From: Michael Eastham <Michael.Eastham@arun.gov.uk>
Sent: 03 June 2020 18:10
To: Planning.Responses <Planning.Responses@arun.gov.uk>
Subject: LU/90/20/DOC - PARCELS A2 & B6, Littlehampton - Drainage Drawings

Please upload onto Ocella the email below which is the revised consultation response from **ADC Drainage Engineers** to discharge of condition application **LU/90/20/DOC**.

Subject: RE: 2020-05-15-19163-PARCELS A2 & B6, Littlehampton - Drainage Drawings

From: Clark, Robert [REDACTED]
Sent: 15 May 2020 10:27
To: Michael Eastham <Michael.Eastham@arun.gov.uk>; Paul Cann <Paul.Cann@arun.gov.uk>
Subject: 2020-05-15-19163-PARCELS A2 & B6, Littlehampton - Drainage Drawings

© This drawing and the building works depicted are the copyright of Banners Gate Ltd and may not be reproduced or amended except by written permission. No liability will be accepted for amendments made by other persons.

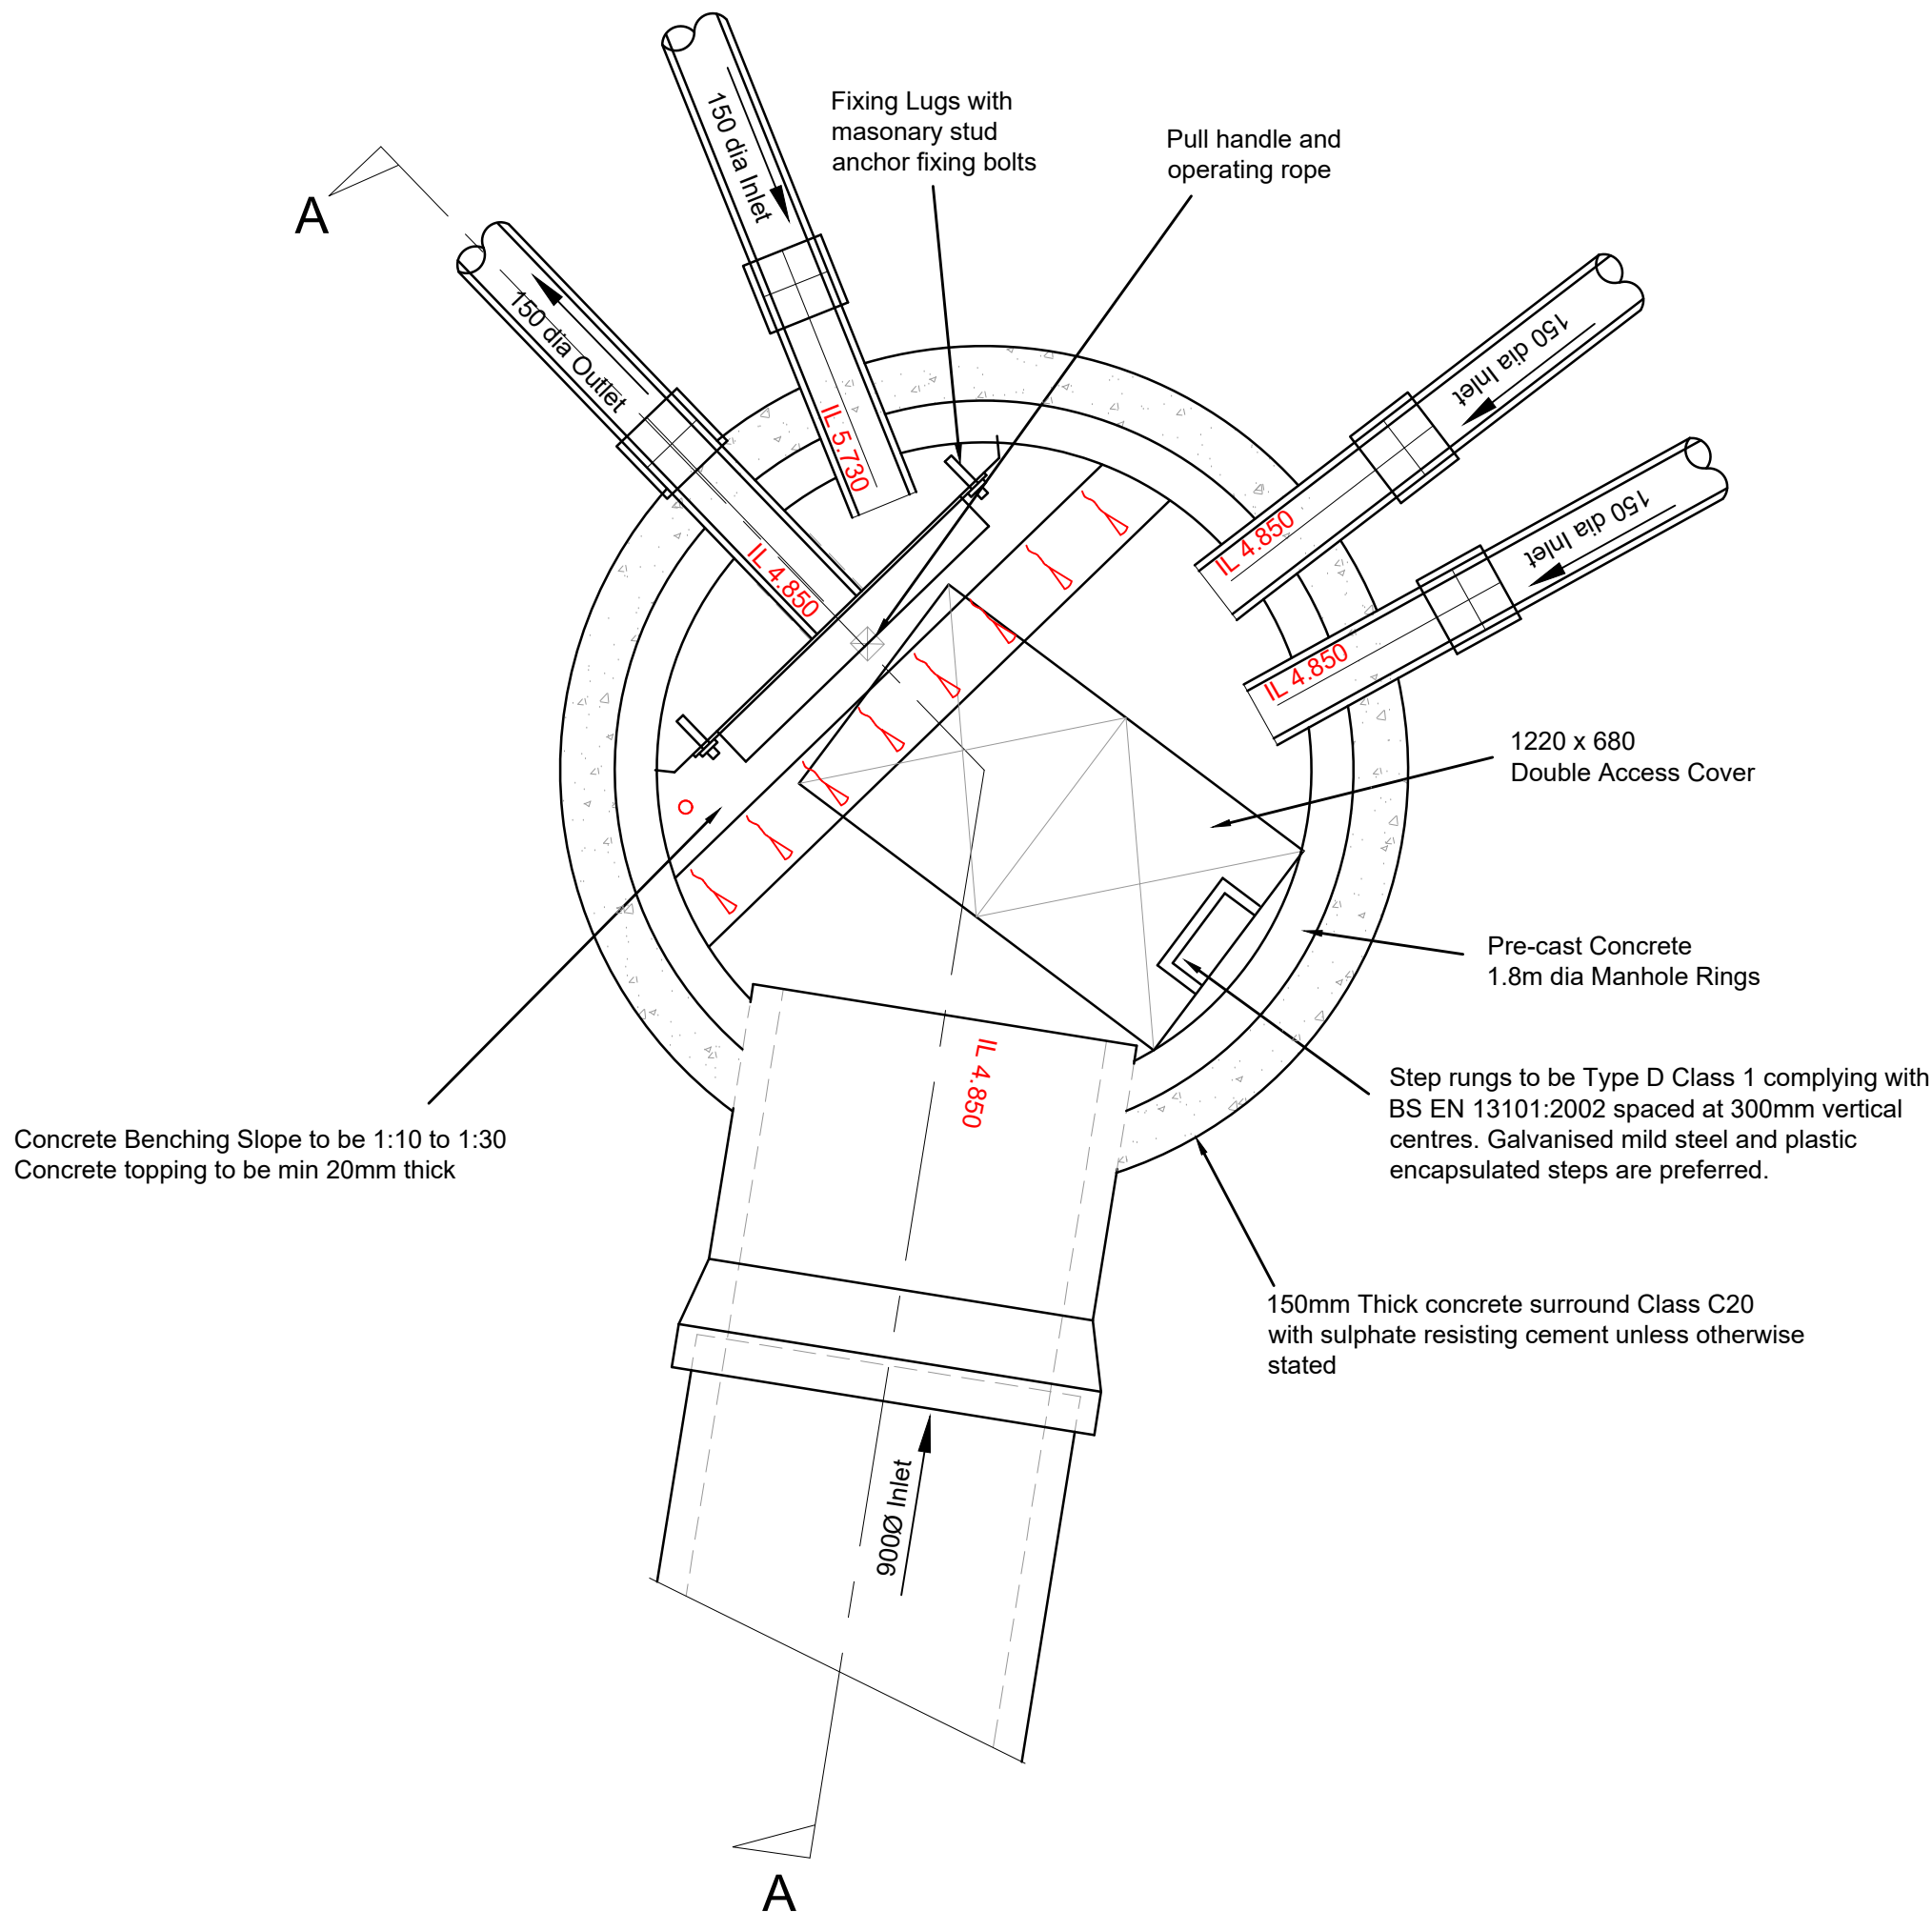
5. Hydrobrake chamber HB02 construction detail – plan view shows incoming 900mm pipe as opposed to 300mm and 1.8m dia rings as opposed to 1.5 dia. Incoming 150mm connections to connect soffit to soffit with 300mm pipe. The gully that is connecting against flow and above hydrobrake is not ideal but willing to accept it in this instance (Section A-A shows it in a different location to the plan view?) *ok*
